DRB Application No.: <b>04DRB-00138 (SBP)</b>	Project # <b>1002805</b>
Project Name: <b>ST ANTHONYS ORPHANAGE</b>	EPC Application No.: 03EPC-01917
Agent: Denish & Kline Associates	Phone No.: <b>842-6461</b>

**TO:** Sheran Matson, DRB Chair  
**FROM:** Carmen Marrone, Staff Planner  
**RE:** **Project #1002805**, Site Plan for Building Permit,  
Lowe's/Walgreens Shopping Center – 12<sup>th</sup> Street and I-40 NW

**RE: St Anthony's Orphanage Tract D (Lowe's & Walgreens)/minor plat**

LANDSCAPE PLAN
LOWE'S OF CENTRAL ALBUQUERQUE
ALBUQUERQUE, NEW MEXICO
PROJECT No: X371804 DRAWN BY: MRW CHECKED BY: RTJ

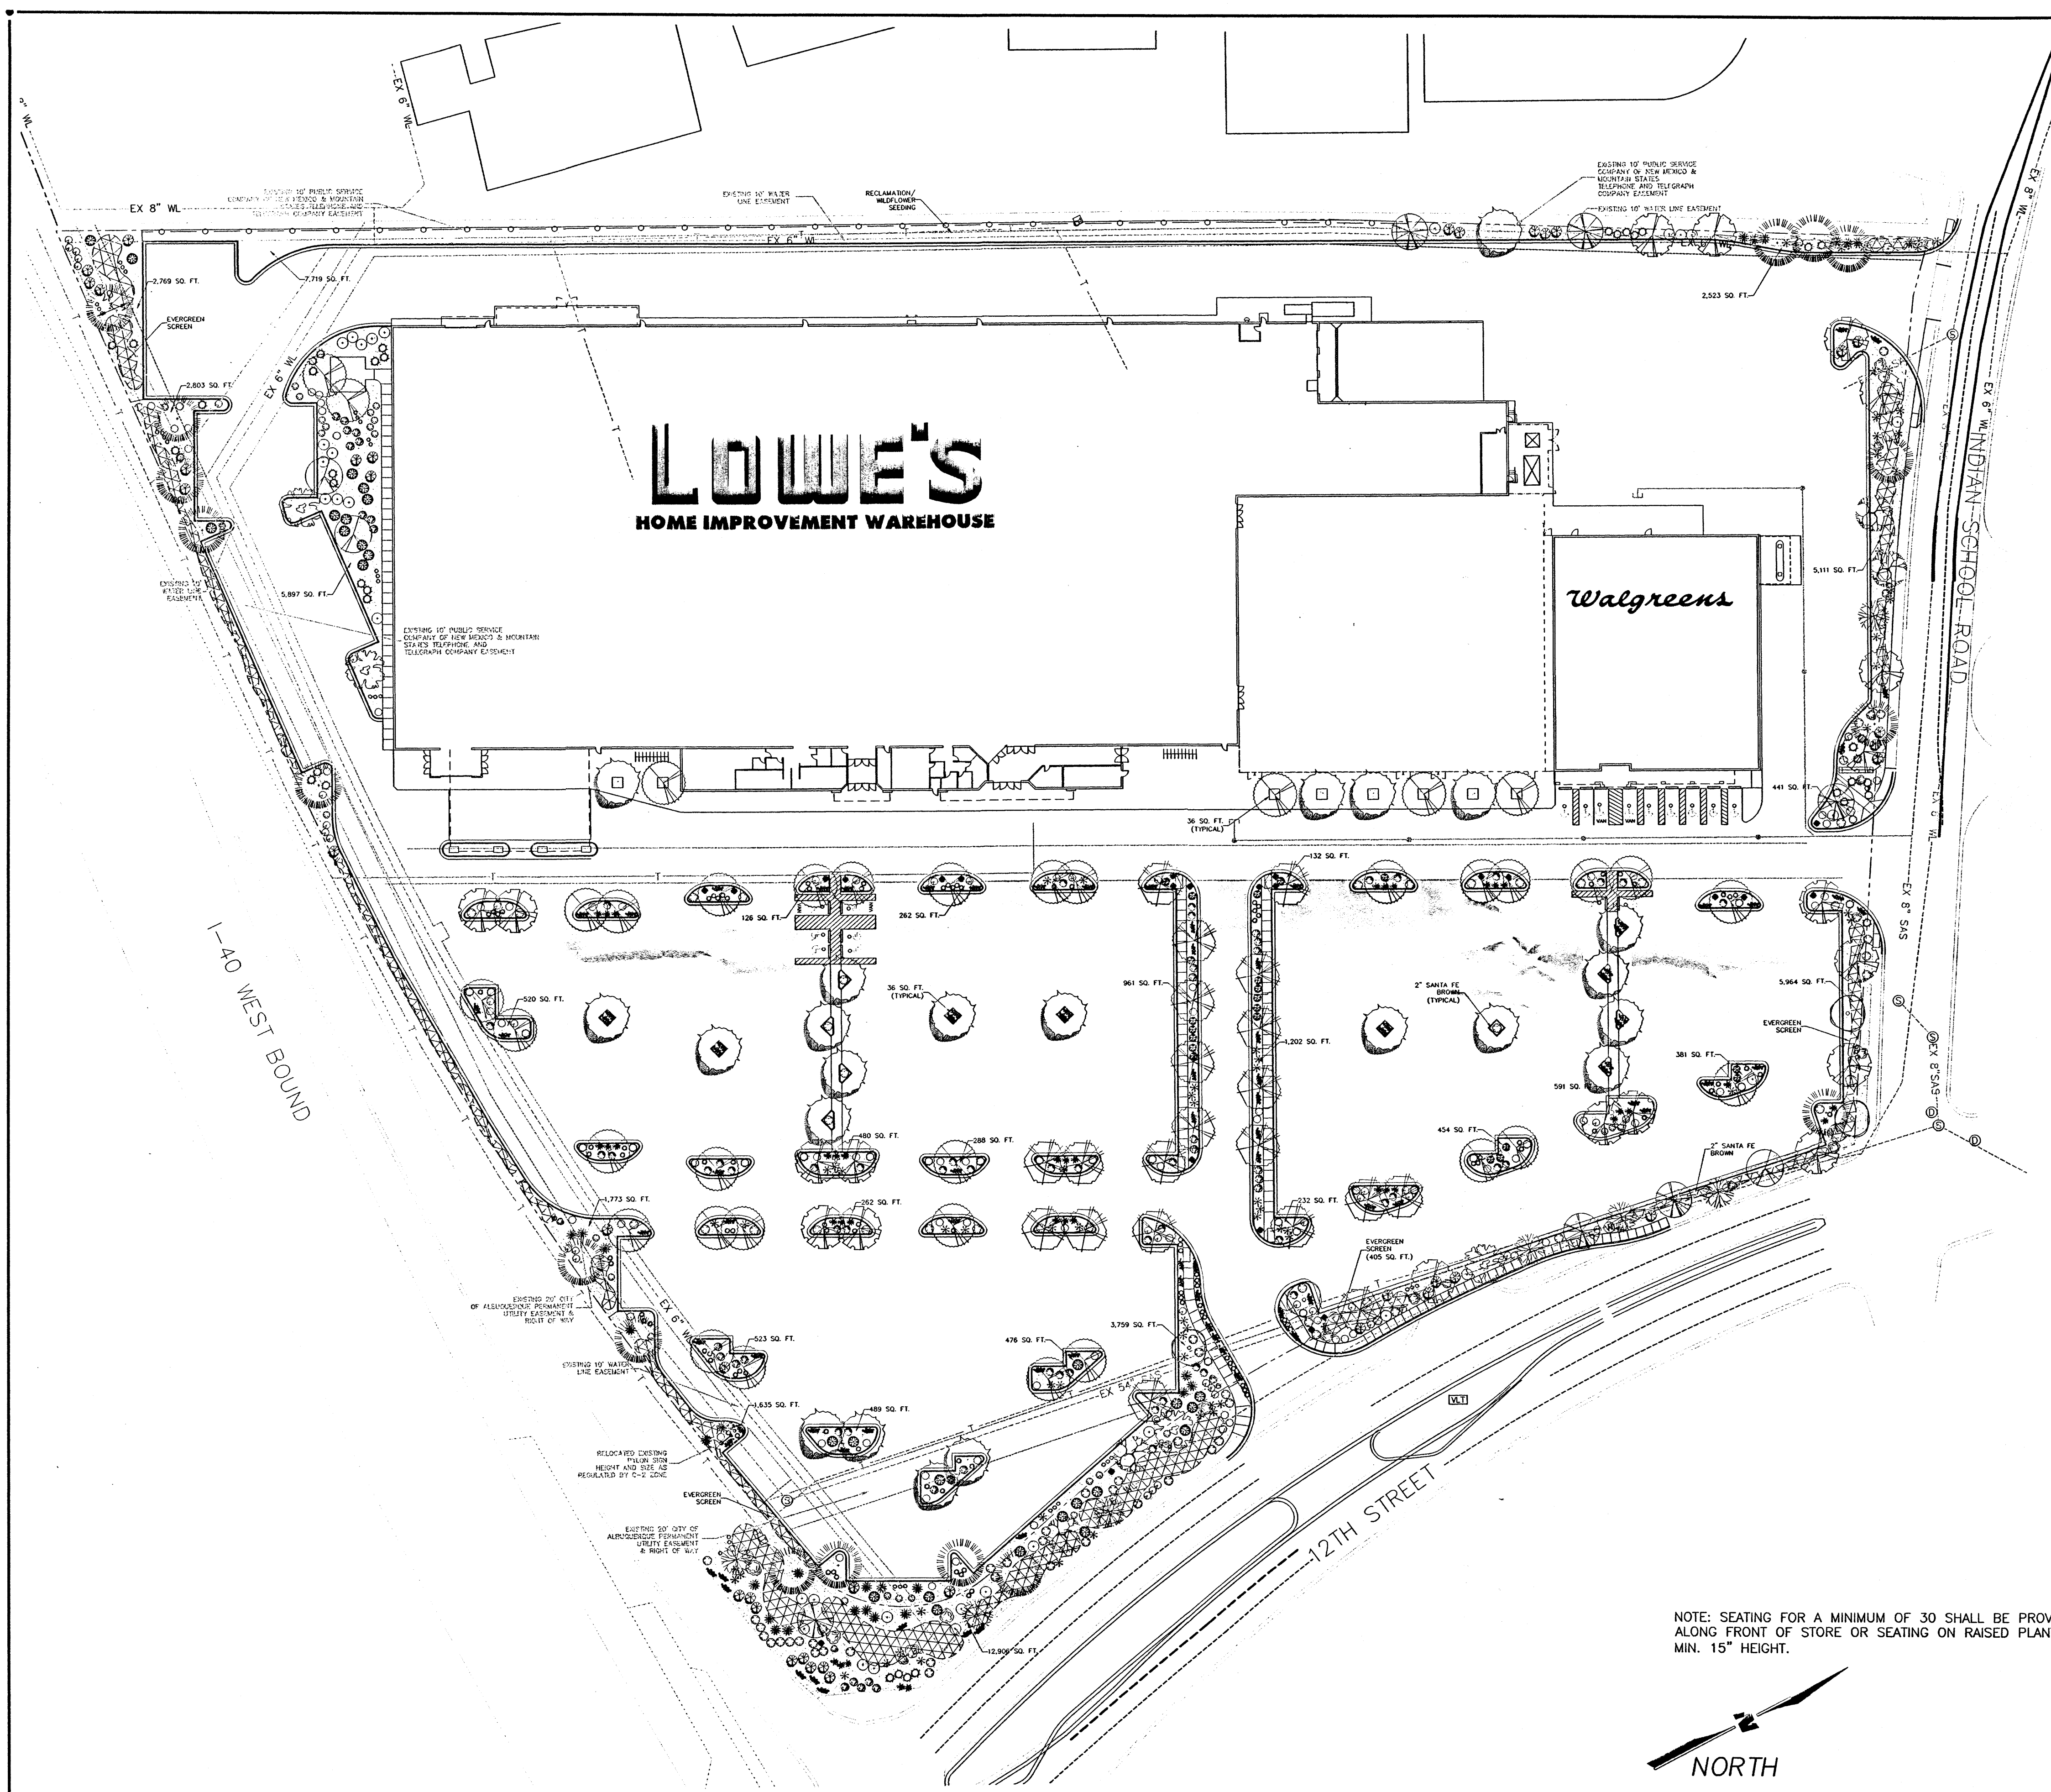
The site plan for building permit for this project was approved by the EPC on December 18, 2003 with conditions. I have reviewed the latest submittal and find that the applicant has generally met all of the conditions imposed by the EPC. The only issue I see is with the requirement for seating along the front of the building (Condition #11). The Landscape Plan states that seating will be in the form of benches but does not describe the width or length of the benches. The site plan also indicates tree planters along the front of the building. I have spoken to the applicant regarding the type of seating that can occur in front of the building and that seating does not necessarily need to be in the form of benches. The tree planters along the front facade could be raised to accommodate seating. After speaking to the applicant we agree that the site plan should have a note that generally states, "A minimum of 30 seats shall be provided along the front facade of the building. Each seat shall be a minimum of 24 inches in width and 15 inches in height. Benches and raised planters will provide the necessary seating." In addition to this note, the site plan should indicate which tree planters will be raised and where the benches will be located.
